Comments for Planning Application 23/04456/FULL1

Application Number: 23/04456/FULL1

Address: 334 High Street Orpington BR6 0NQ

Proposal: Single storey rear extension to existing restaurant for additional customer seating and storage (Retrospective)

Proposed Side/Southern Elevation/View from no. 336 (1:100)

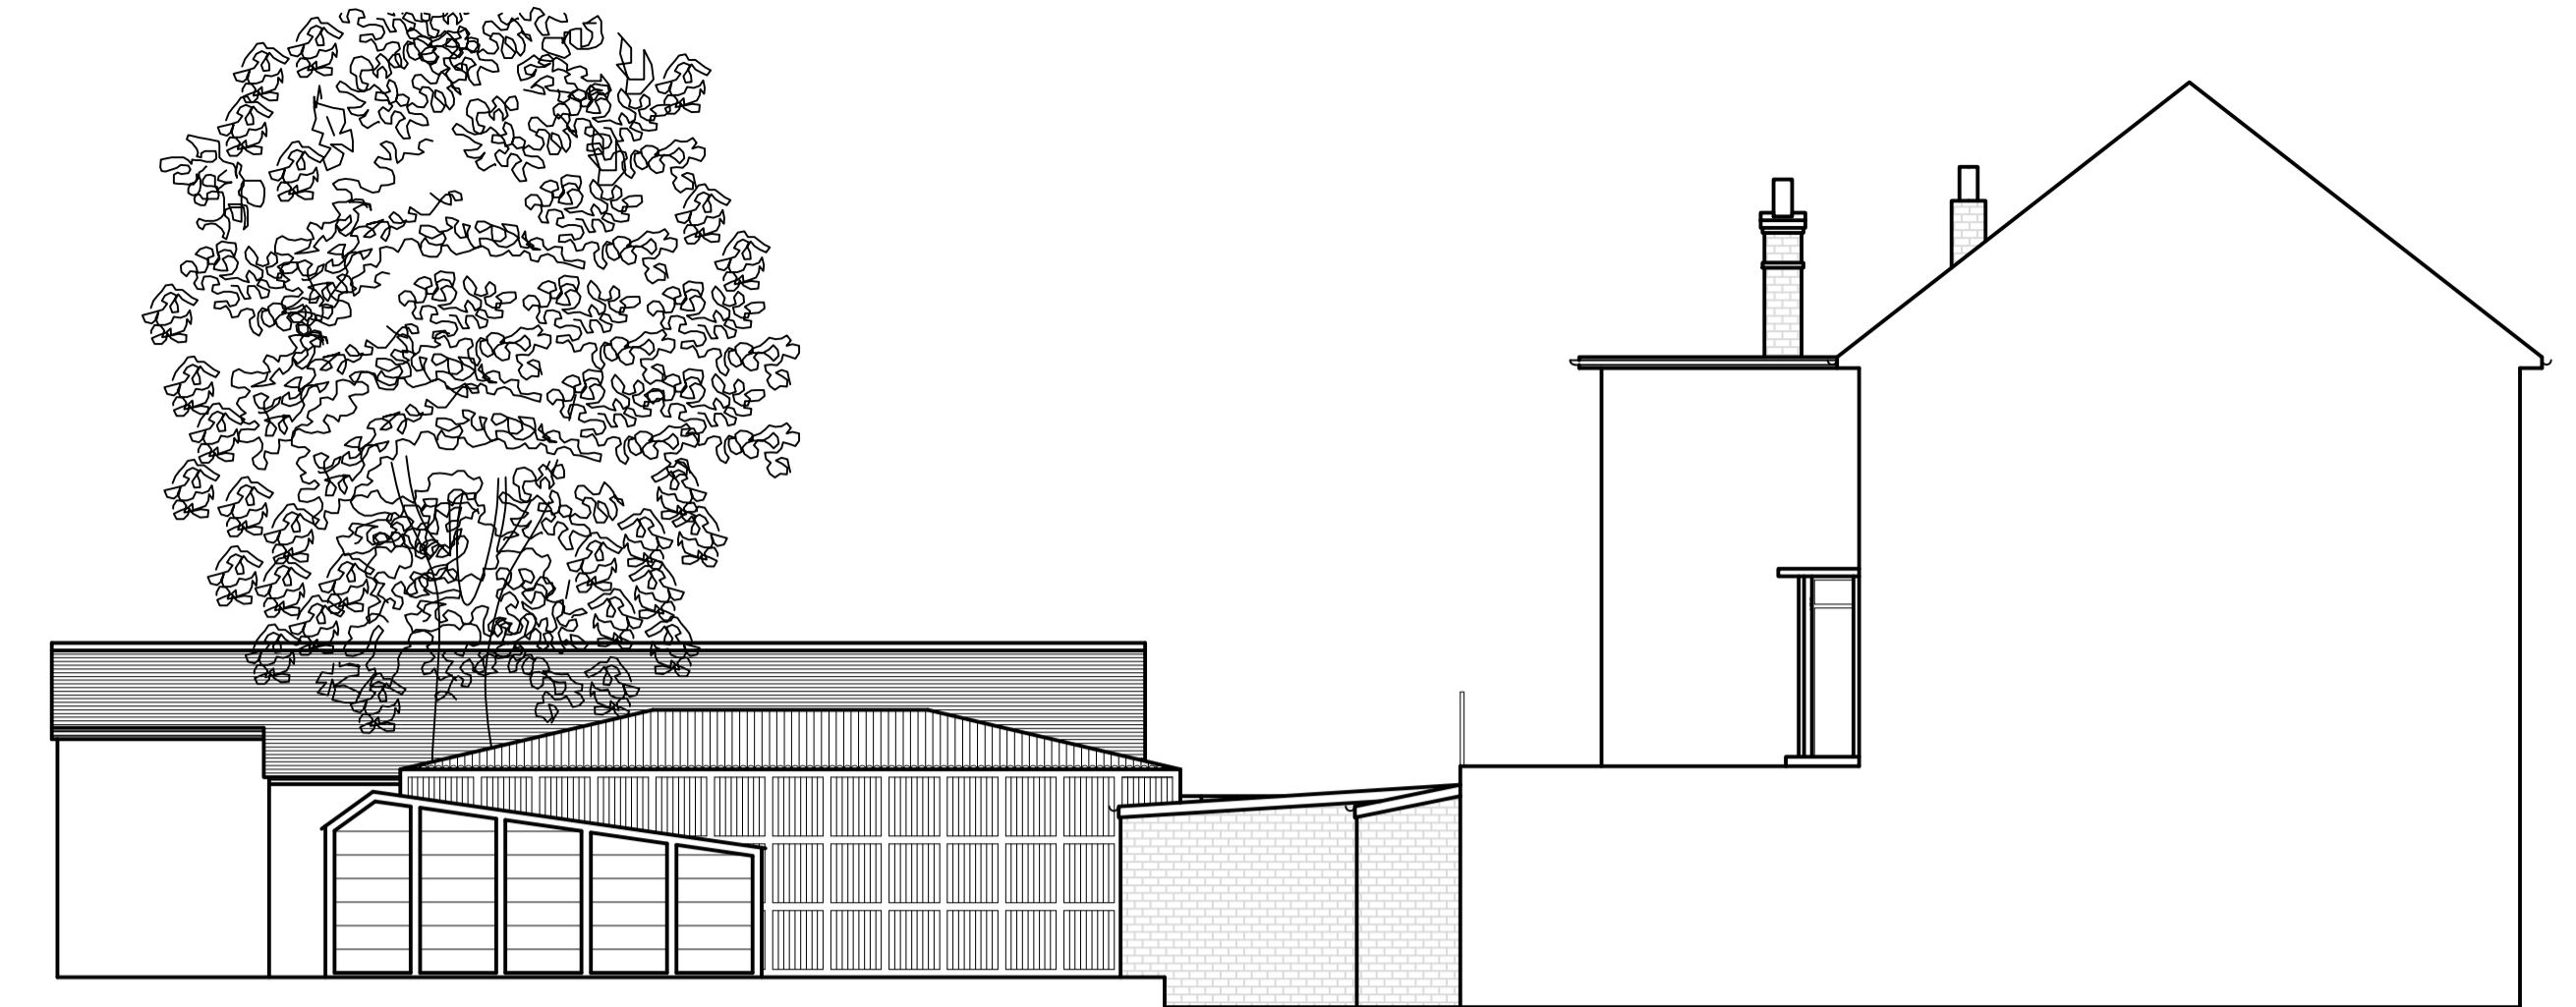
Comment: THE LOCATION AND STRUCTURE APPEARS TO BE VERY CLOSE TO THE SINGLE STORY GARAGE AND PLANNING SHOULD CHECK THE BOUNDRY LINE AND LAND THAT IS JOINING 336 HIGH STREET ORPINGTON ... REAR OF , GARAGE AREA . Has consideration be given to noise ? after hours , as all occupants that are Residential are directly above the adjacent shops 336a 332a particually 336a . In addition access to 336 and 336a which is adjacent plus the garage may experience access to the stair case and fire escape if users of the proposed resteraunt extension park cars at the rear of 334 of which there is no parking once the extension is erected please check fire escape areas
